### **Rollin Ridge Estates, SP-18-001**

**Please accept the following comments from El Paso County Public Health regarding the rezoning request referenced above:**

DATE	10/25/17
SCALE	AS SHOWN
DWG. NO.	1708937
FIGURE NO.	10
DRAWN	TLL
CHECKED

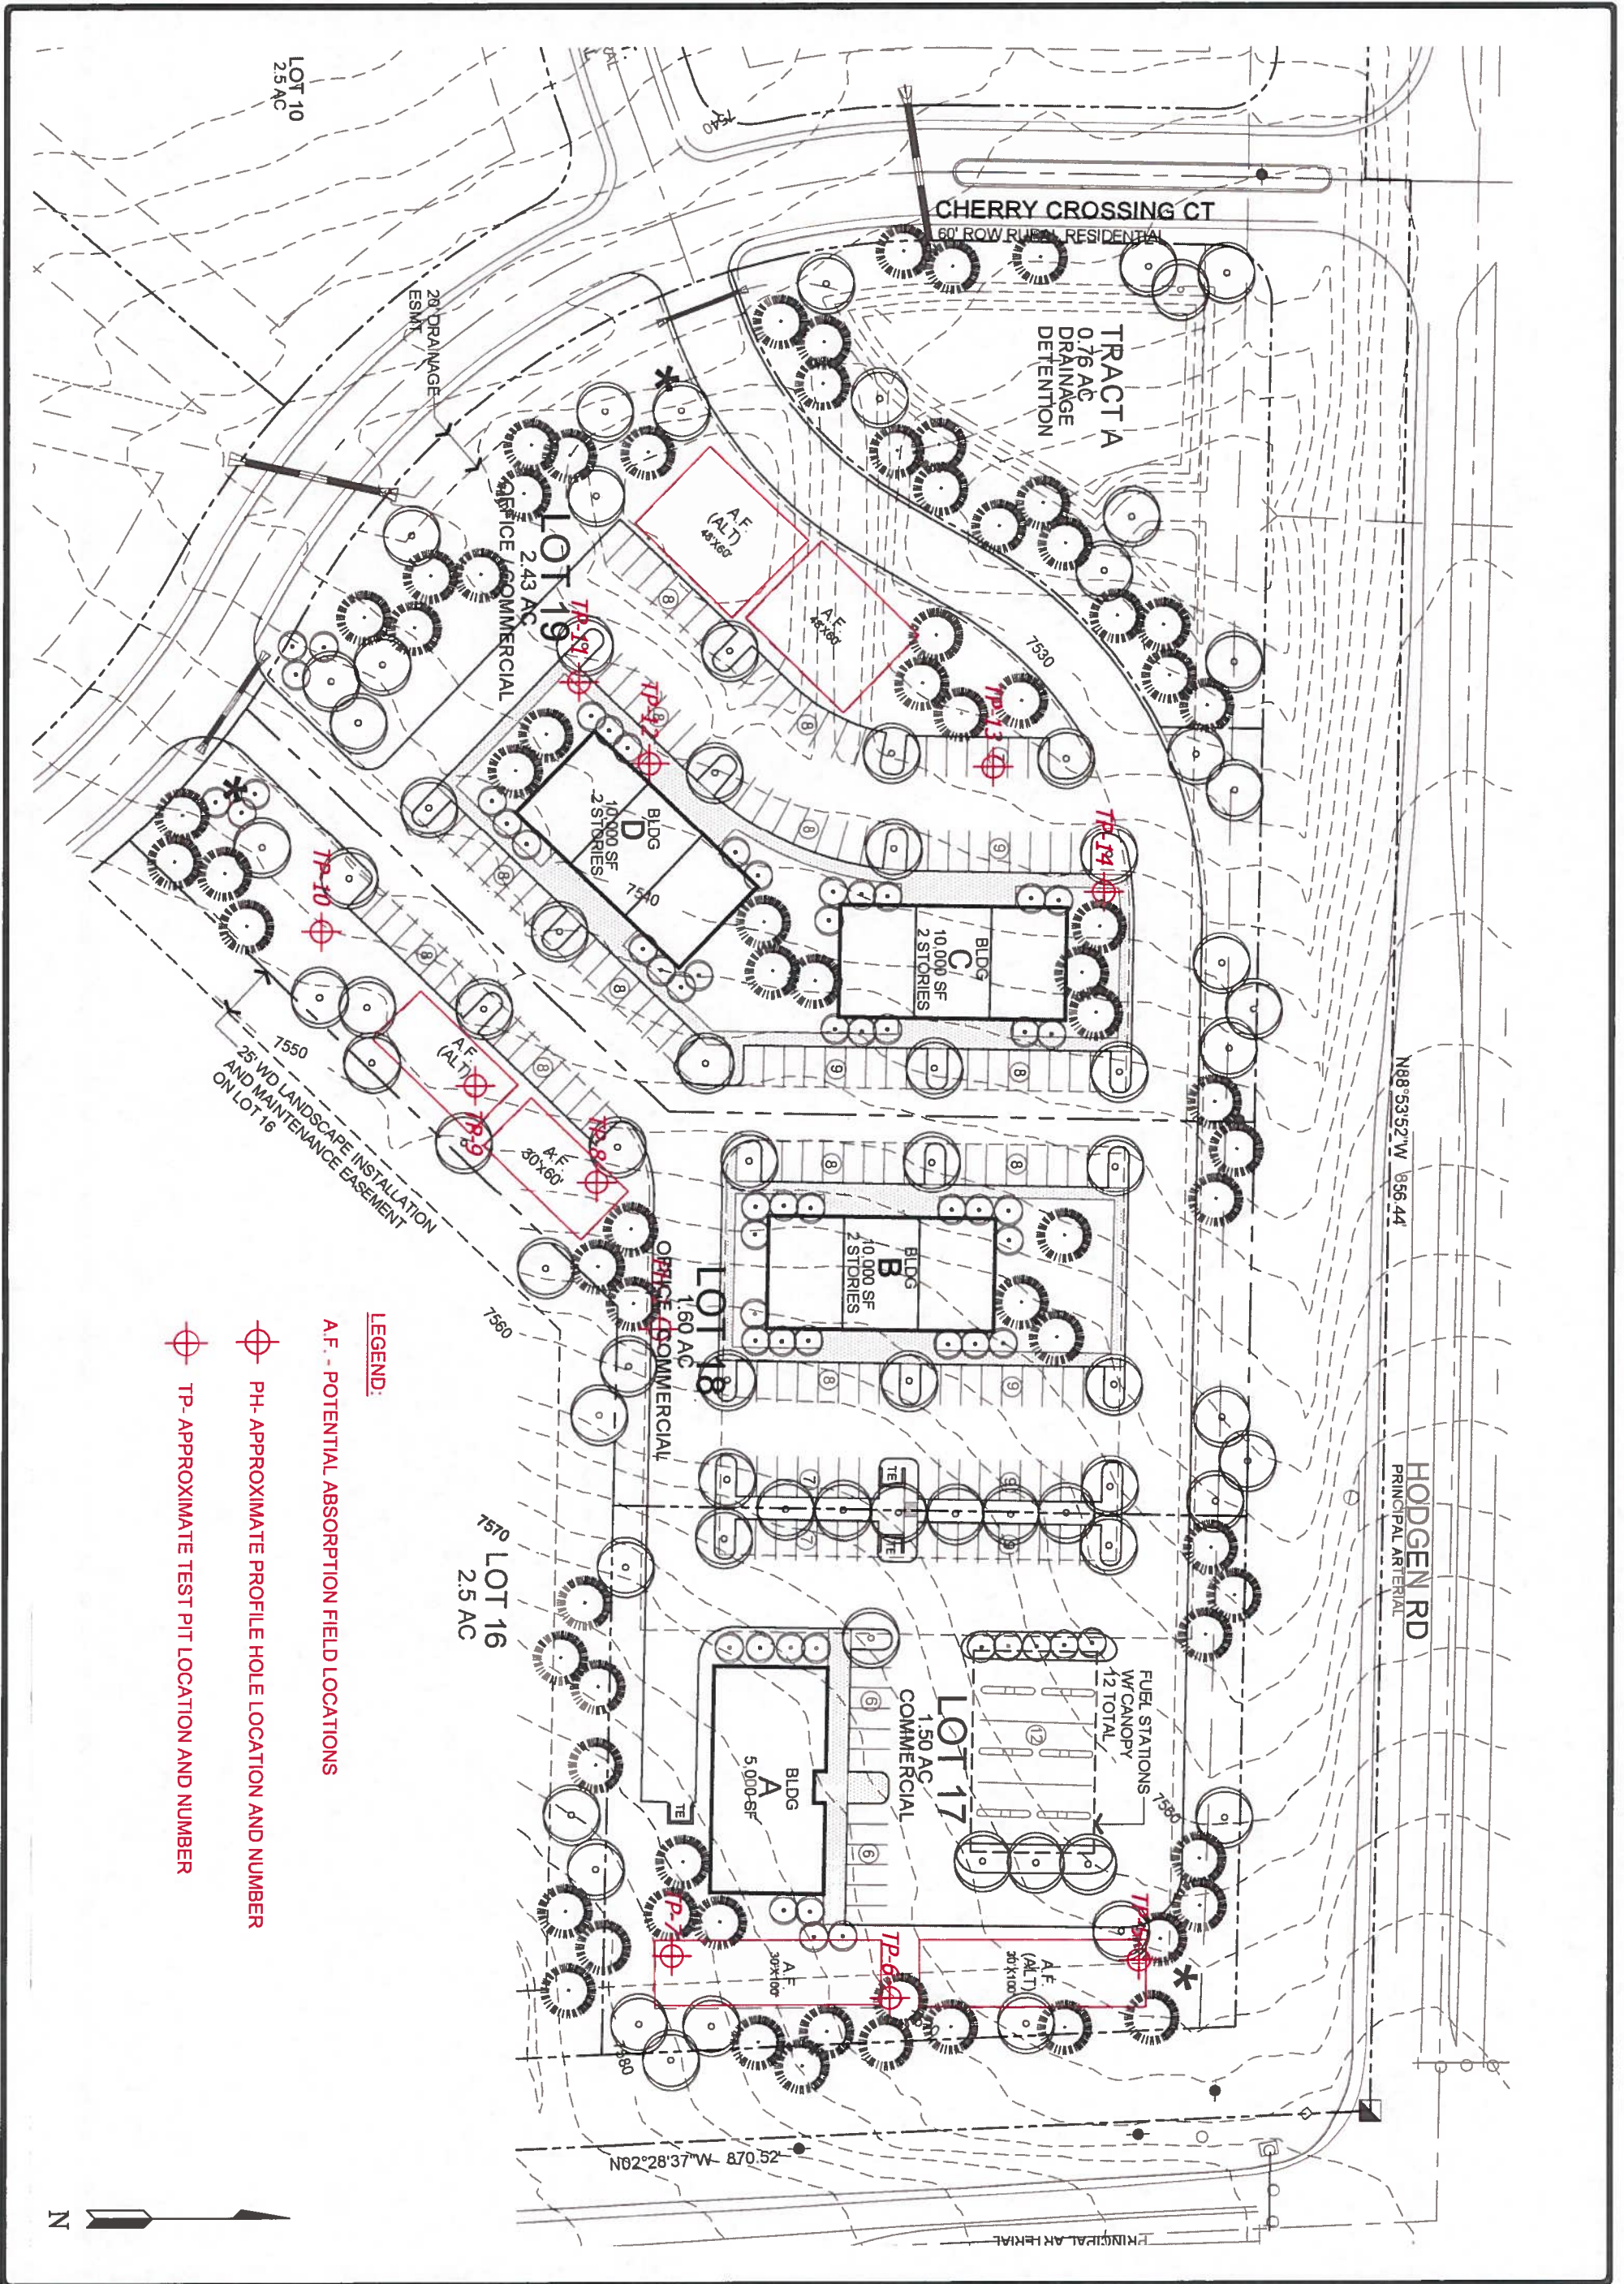
- **The 24Nov2017 Entech Engineering, Inc., Soil, Geology, Geologic Hazard, and Wastewater Study provides more information on the proposed commercial use of Tract B than the Letter of Intent. Lots 17, 18, and 19 are discussed in the Entech report which further complicates how this is possible on only a 5.35 acre site. The lots would be less than the 2.5 acre minimum lot size required in the Land Development Code. Although this is not an El Paso County Public Health regulation, it remains an EPCPH concern.**

EXHIBIT C
ROLLIN RIDGE ESTATES SUBDIVISION
PRELIMINARY PLAN &
CONCEPT DEVELOPMENT PLAN

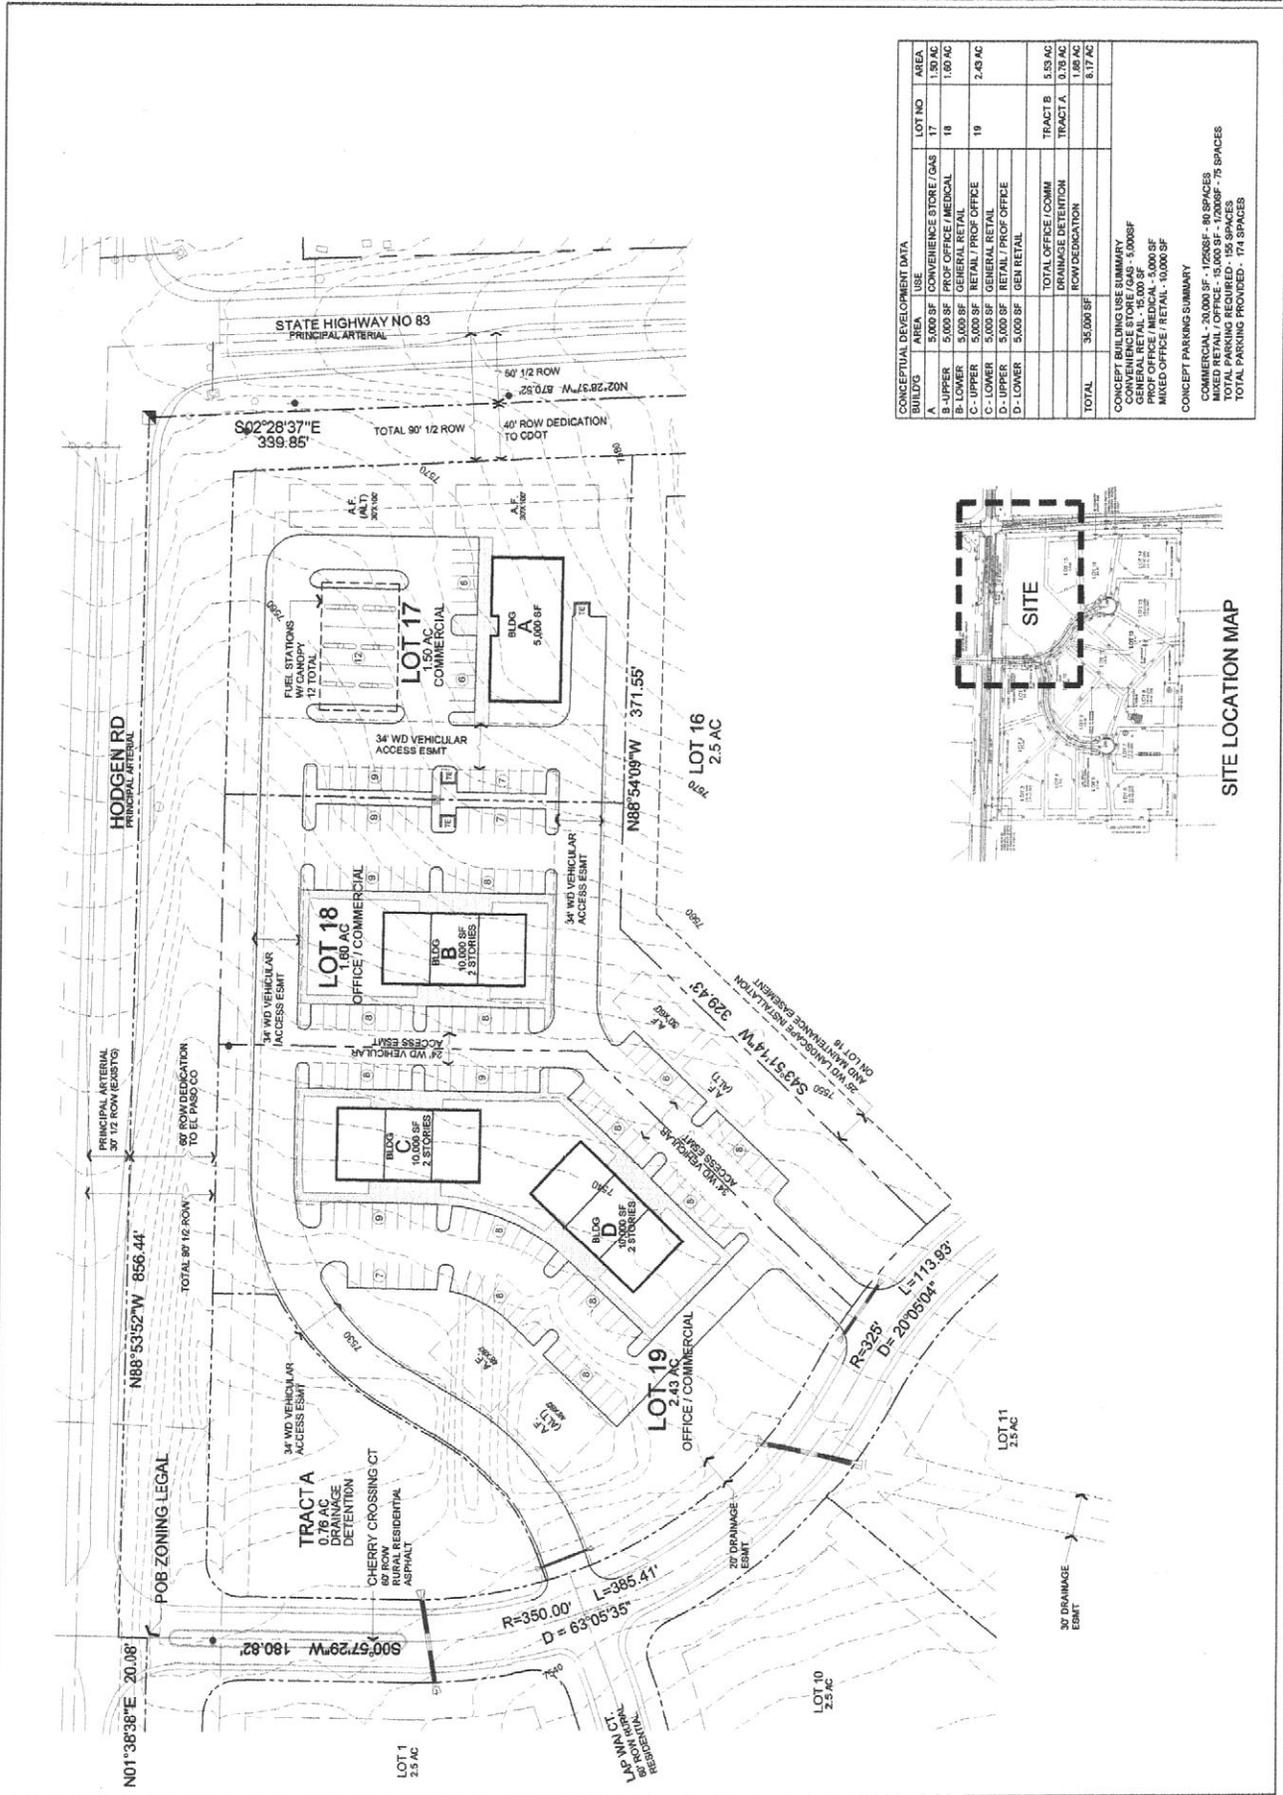
- **El Paso County Public Health (EPCPH) has several concerns regarding the proposed future zoning from RR-5 to PUD Commercial of the 5.35 acre Tract B. The number of proposed commercial structures planned for the 5.35 acre tract presents the following concerns:**

- **The proposed commercial uses (and subsequently their designed wastewater flows) and how to locate primary and secondary OWTS sites for each structure on only 5.35 acres.**

- **Additional concern is will there be 1 well or 3 wells? Three wells on a 5.35 acre site will sterilize even more area which is a major concern with the development of Tract B.**
